REFUSAL OF PLANNING PERMISSION

APPLICATION NO. 2016/1507

Proposal Erection of detached garage.

At 186 Milton Road, Hoyland, Barnsley, S74 9BW

SITE PLAN  
SCALE 1:500 AT A3

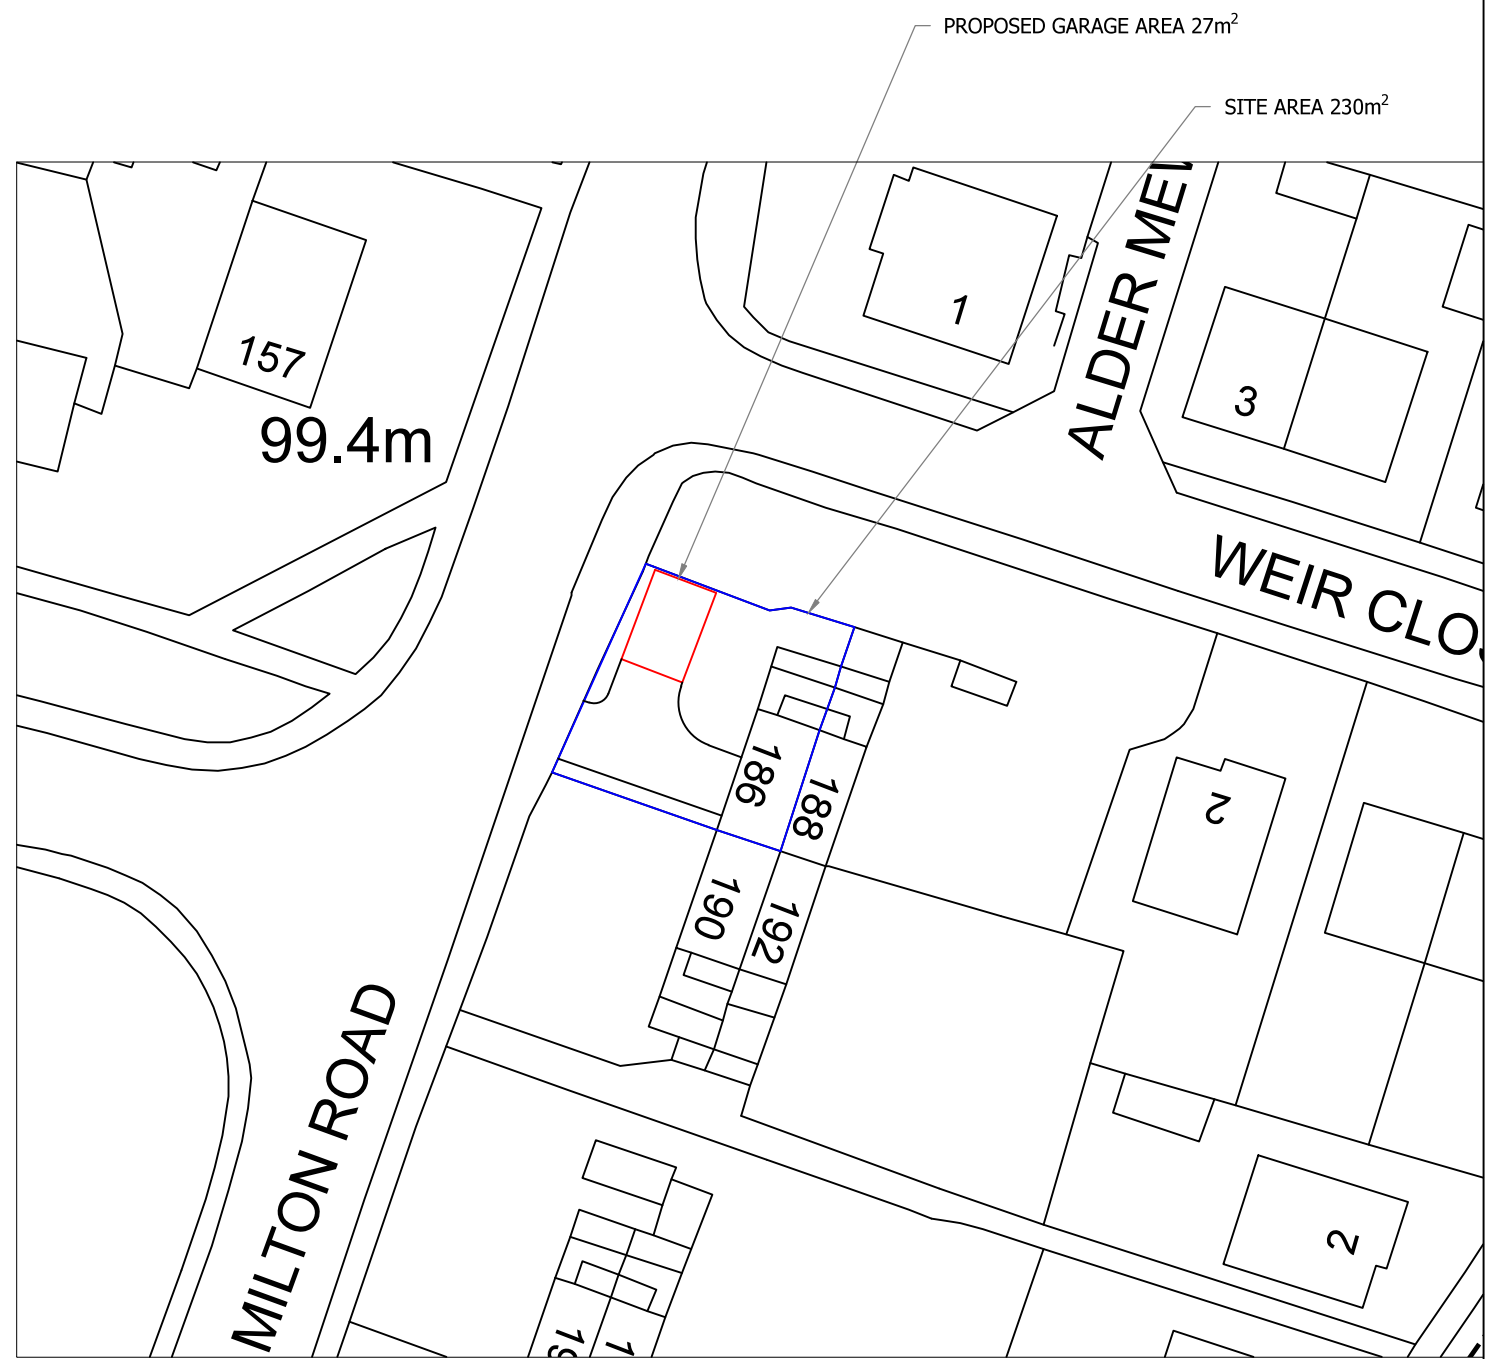
- 2 In the opinion of the Local Planning Authority the proposed development would be an incongruous addition to the street scene due to its position forward of the main front elevation of the dwelling, on a prominent corner plot that would fail to appear subservient. The development would therefore be contrary to the House Extensions SPD and the Core Strategy policy CSP29 'Design' which states that detached garages positioned between the house and a road should be avoided.

PROPOSED BLOCK PLAN  
SCALE 1:100 AT A3

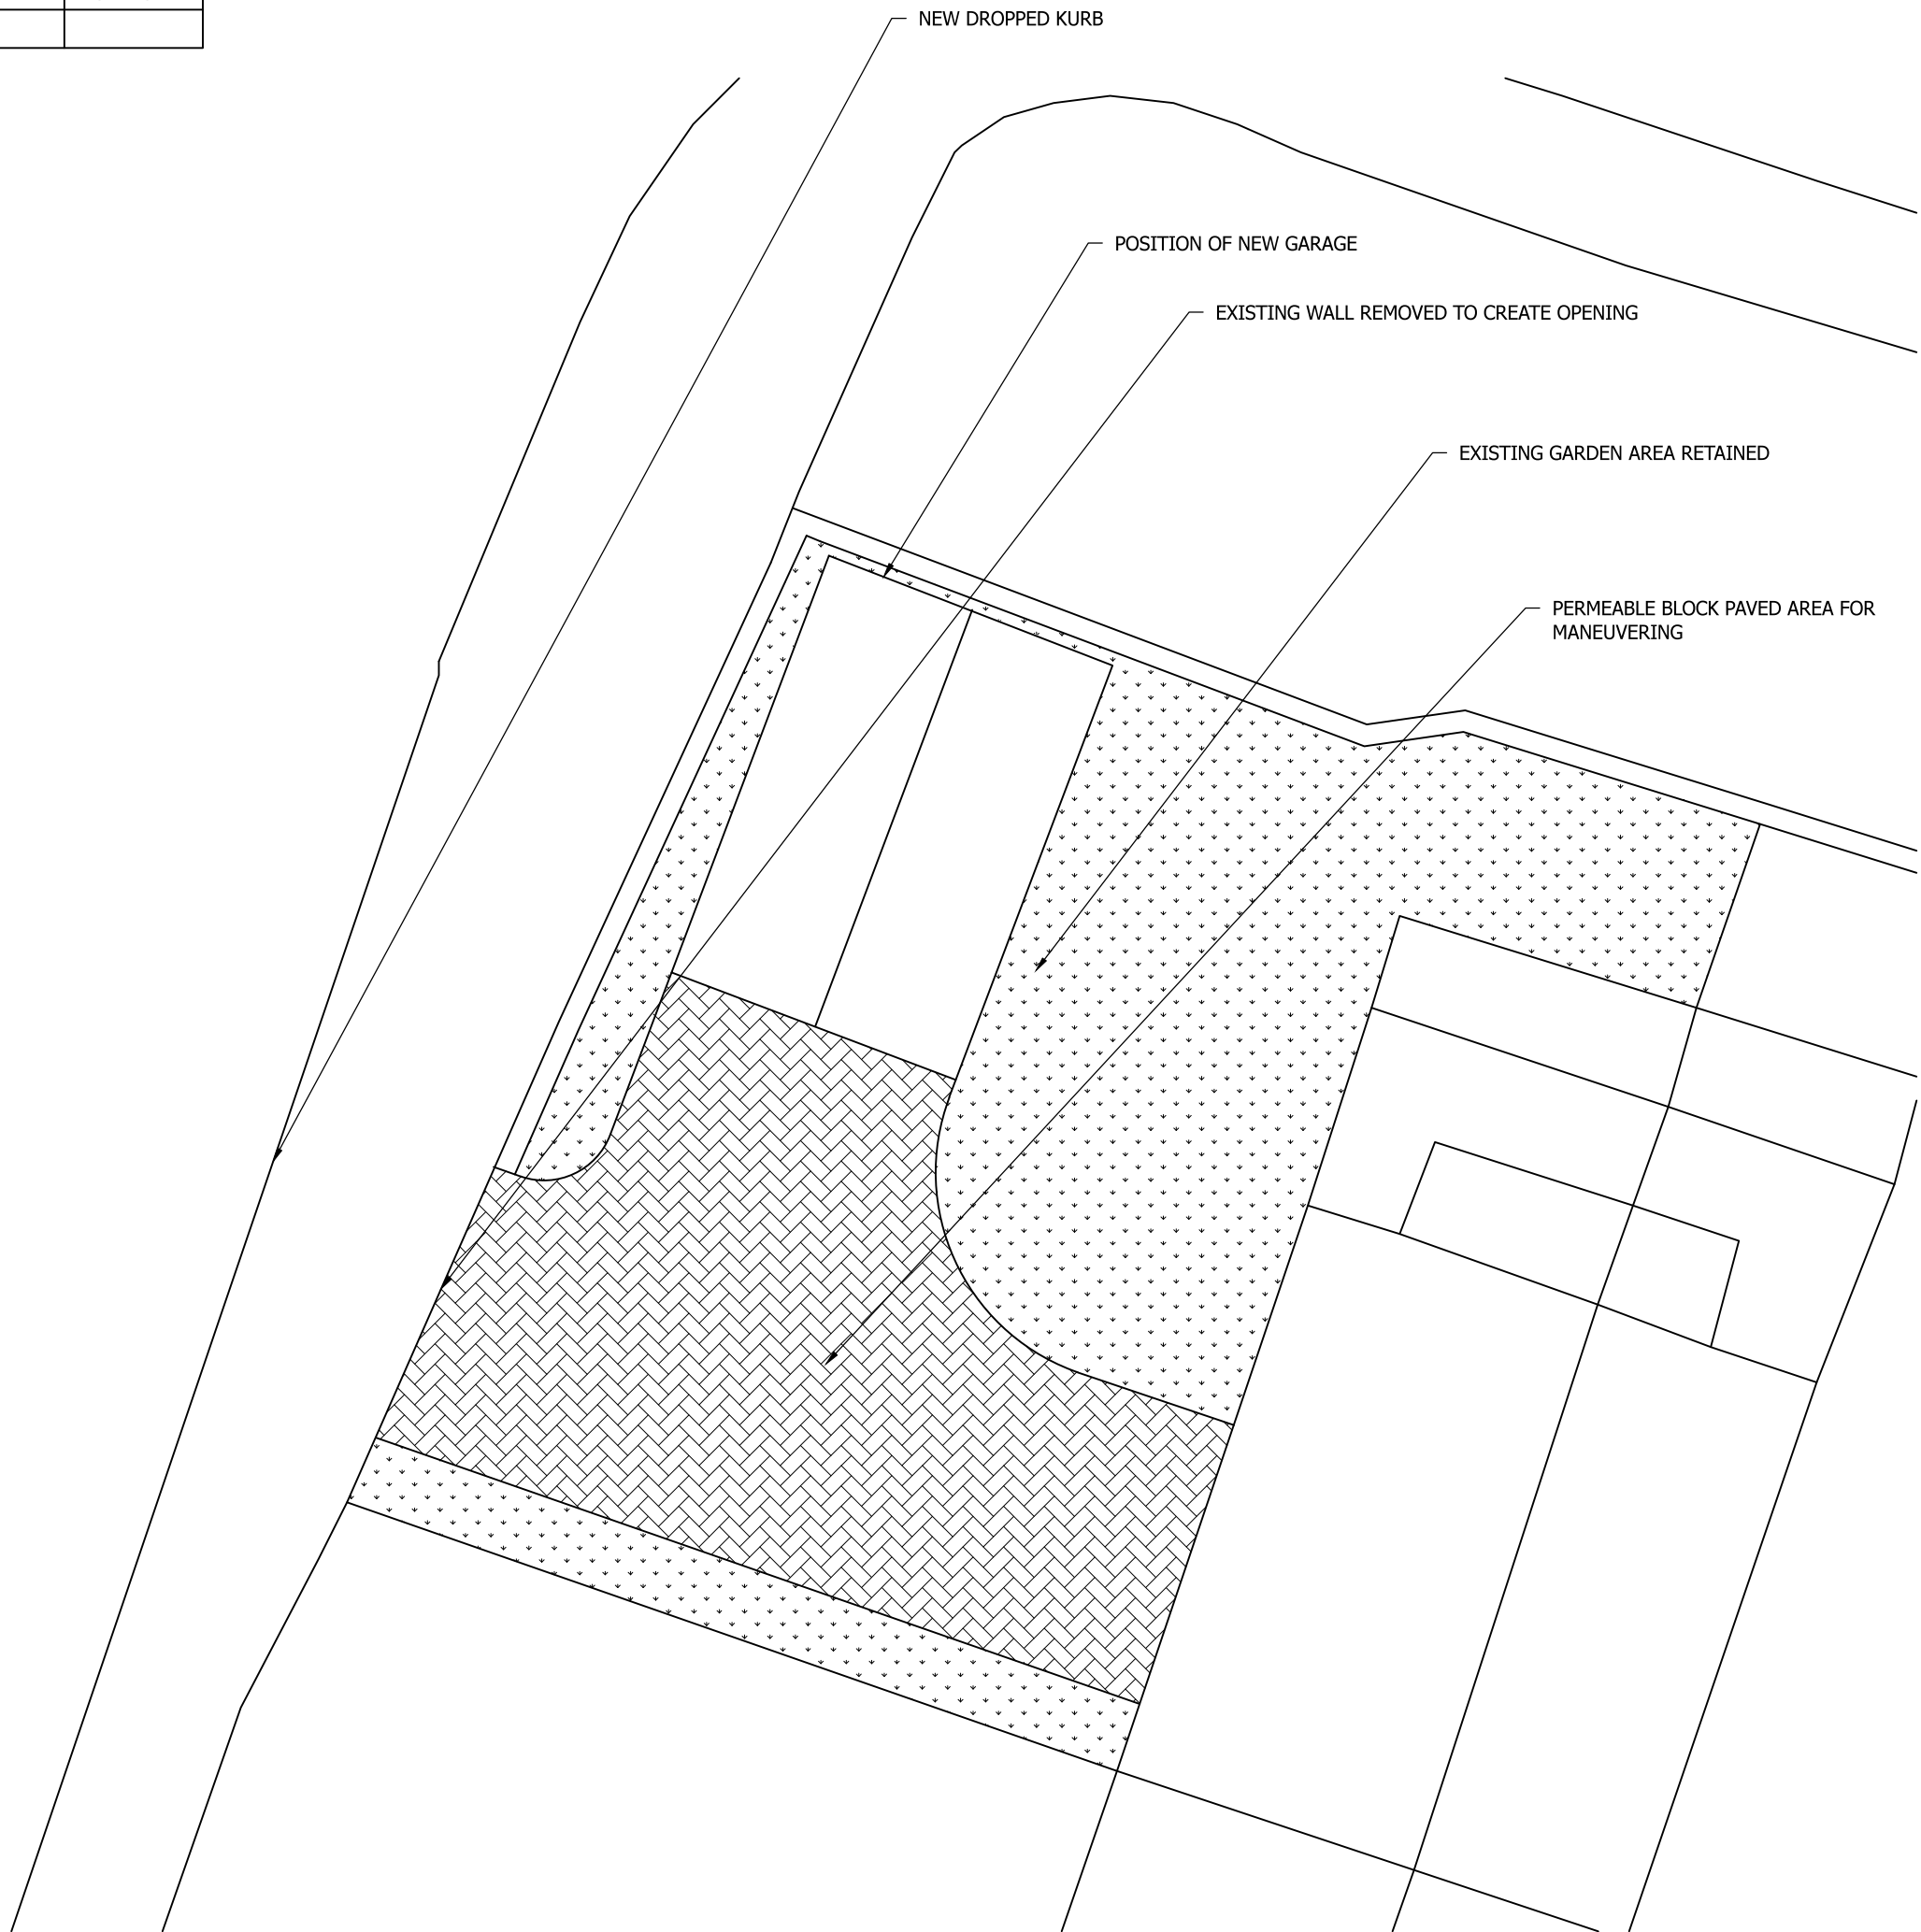
- 1 In the opinion of the Local Planning Authority the proposal is unsatisfactory with regards to highway safety considerations in that vehicular accessing/egressing the site would obstruct other vehicles approaching the junctions of Weir Close and Cloughfields Road at each side of Milton Road and would be detrimental to the free and safe flow of vehicular and pedestrian users of the highway. This is further exacerbated by the inability of vehicles to enter and exit the highway in a forward gear as there would be insufficient turning space within the site. The proposal is therefore contrary to Core Strategy policy CSP26 'New Development and Highway Improvement'.

- 3 The proposed garage, vehicular access and manoeuvring area would occupy more than half of the garden space belonging to the property, failing to maintain a suitable standard of residential amenity for the occupants of the property making the proposal contrary to the House Extensions SPD and the Core Strategy policy CSP29 'Design'.
